**Written Response Sunnica Energy Farm
Ref no. 20030335**

The Lady Frances Peyton Hospital Almshouse Charity was established in the 16th Century to provide accommodation for those in need within Isleham. The Charity is an integral part of the community to promote Isleham as a fine place to live.

Drawing Title
**FIGURE 10-14B
LANDSCAPE MASTERPLAN
SUNNICA EAST SITE A**

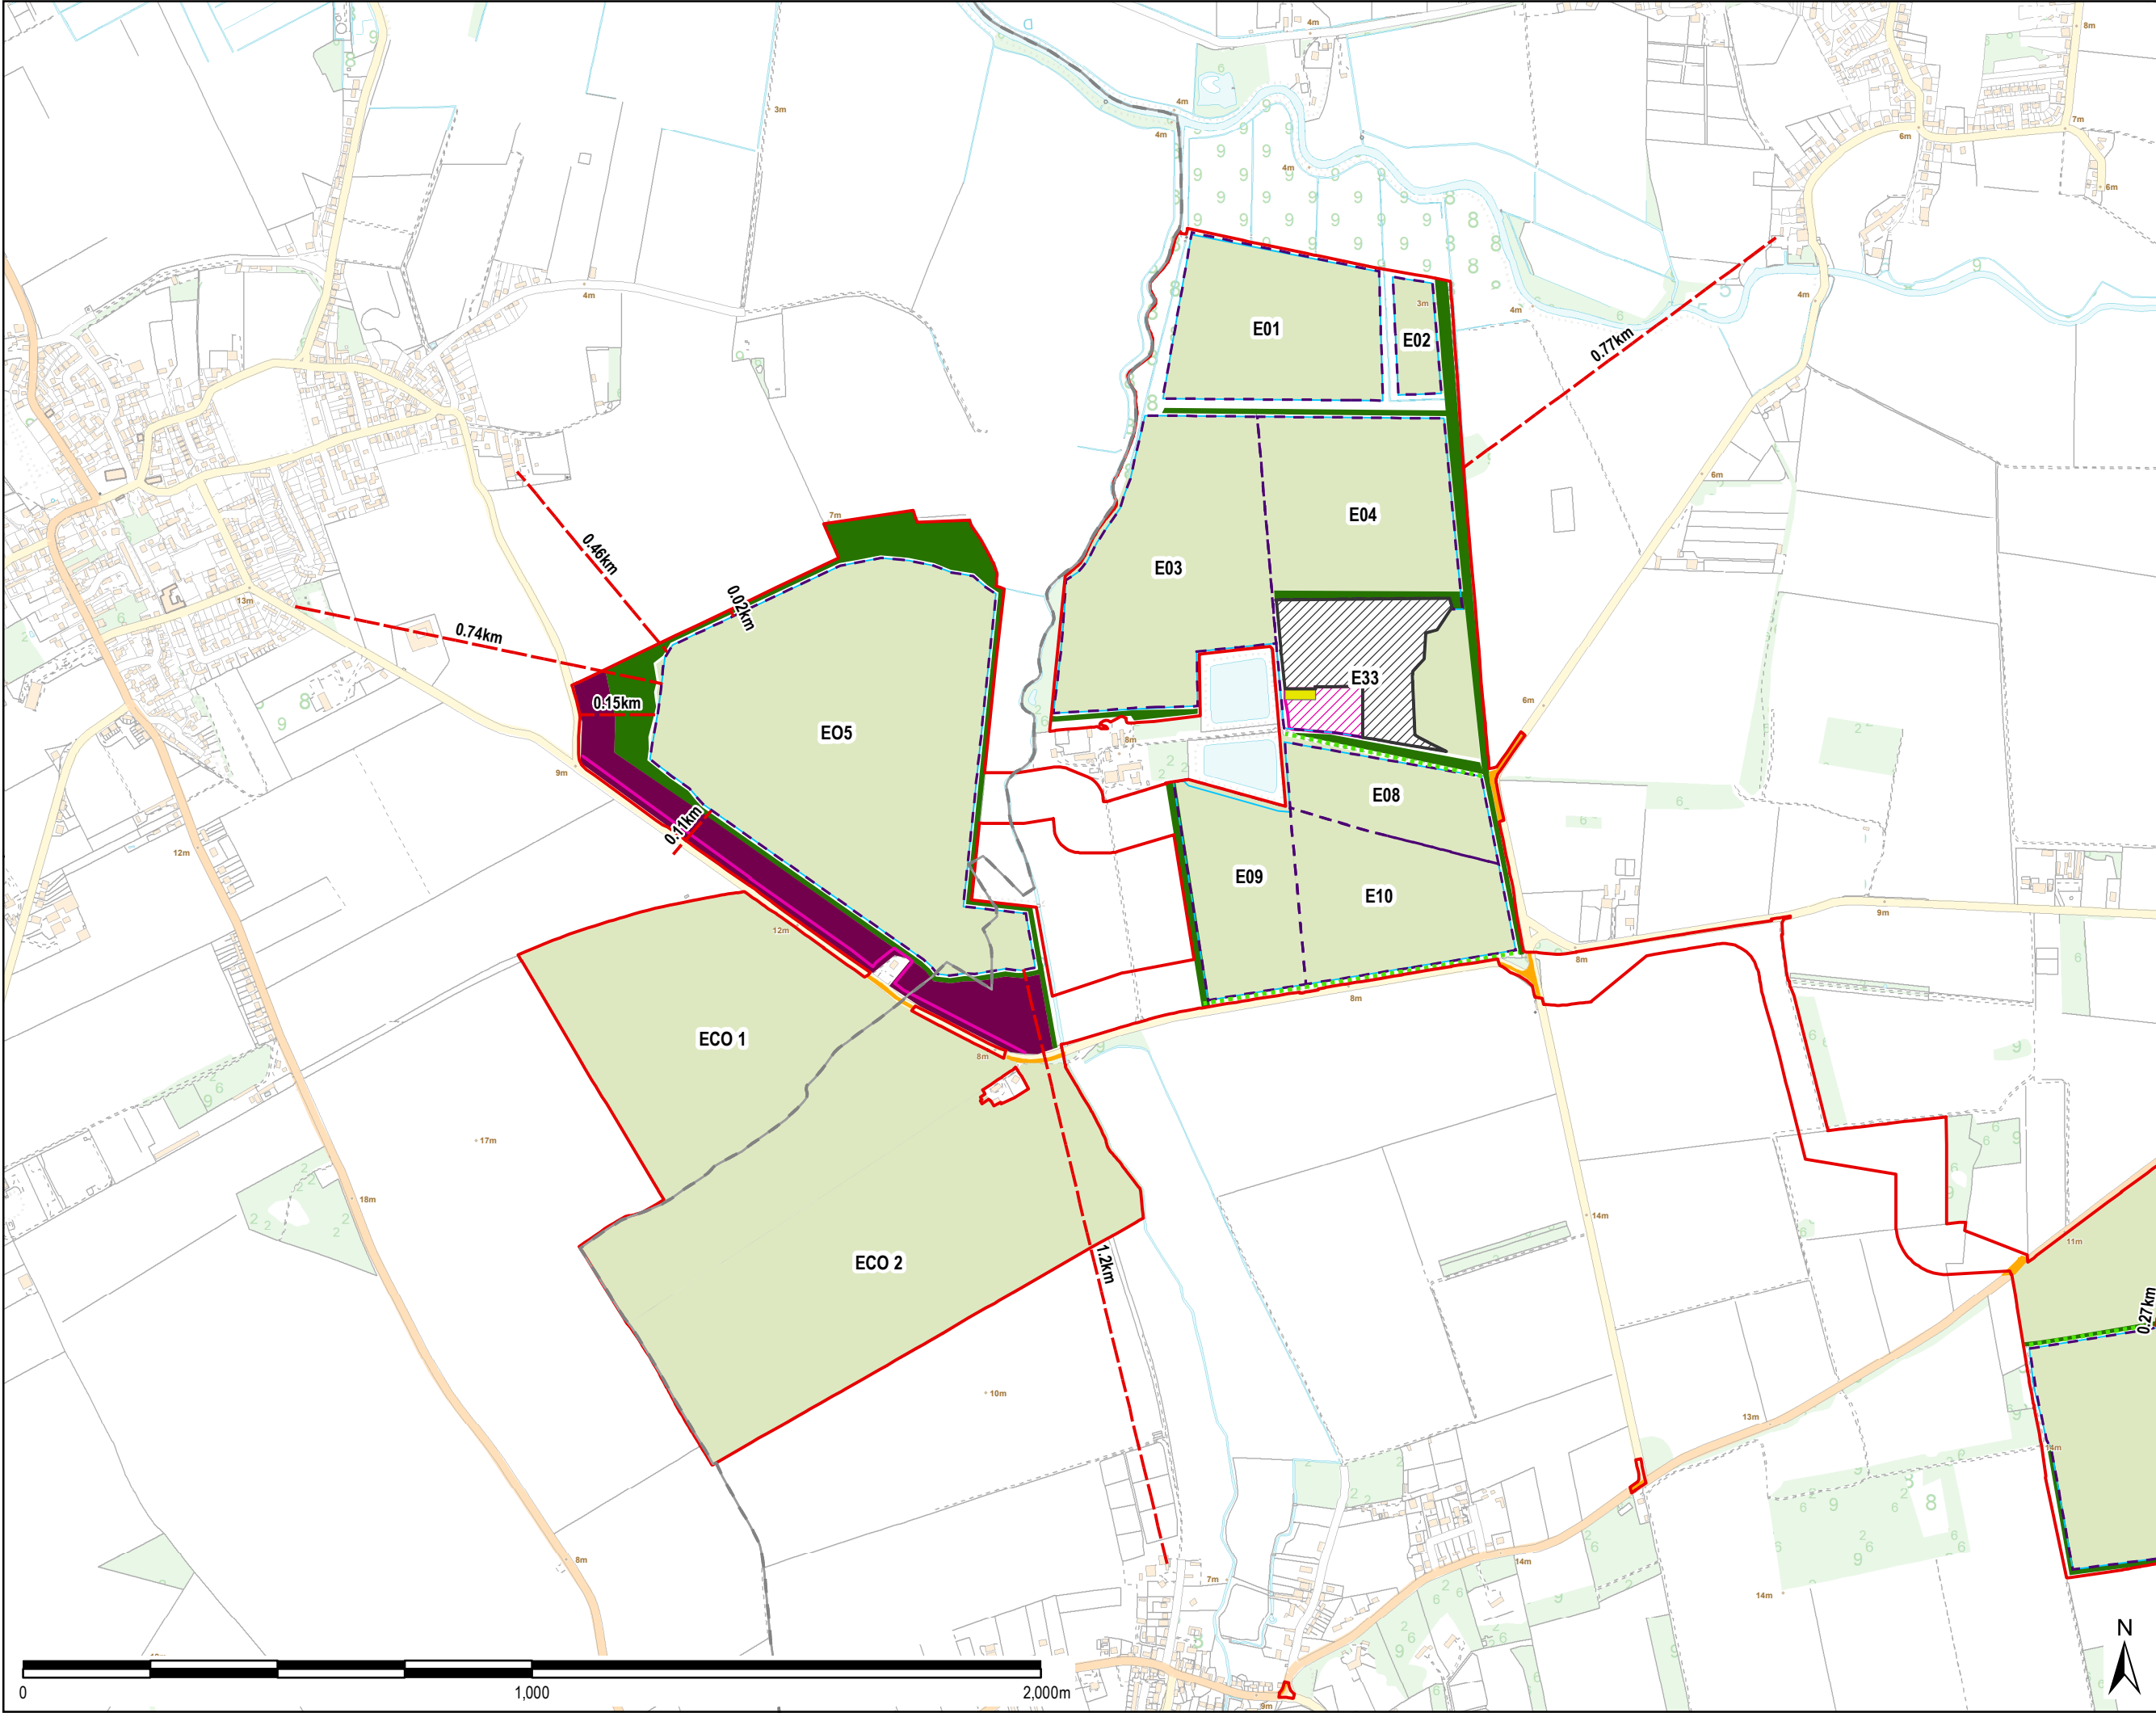
The Charity has a long history within Isleham. The hedging and tree belts proposed at EO5 will destroy the historic long and wide ranging views over this area both to and from the village. This proposal will dramatically shorten views in an area that has historically not been hedged or heavily wooded. It is an open agricultural landscape connecting our fen edge village to Breckland and the Fen. It sets Isleham in the landscape of being visible from all routes to it across open fields and is enjoyed by both residents and visitors. There is no mitigation that can be achieved. This shows complete disregard by Sunnica of what it recognises are views of "high value".
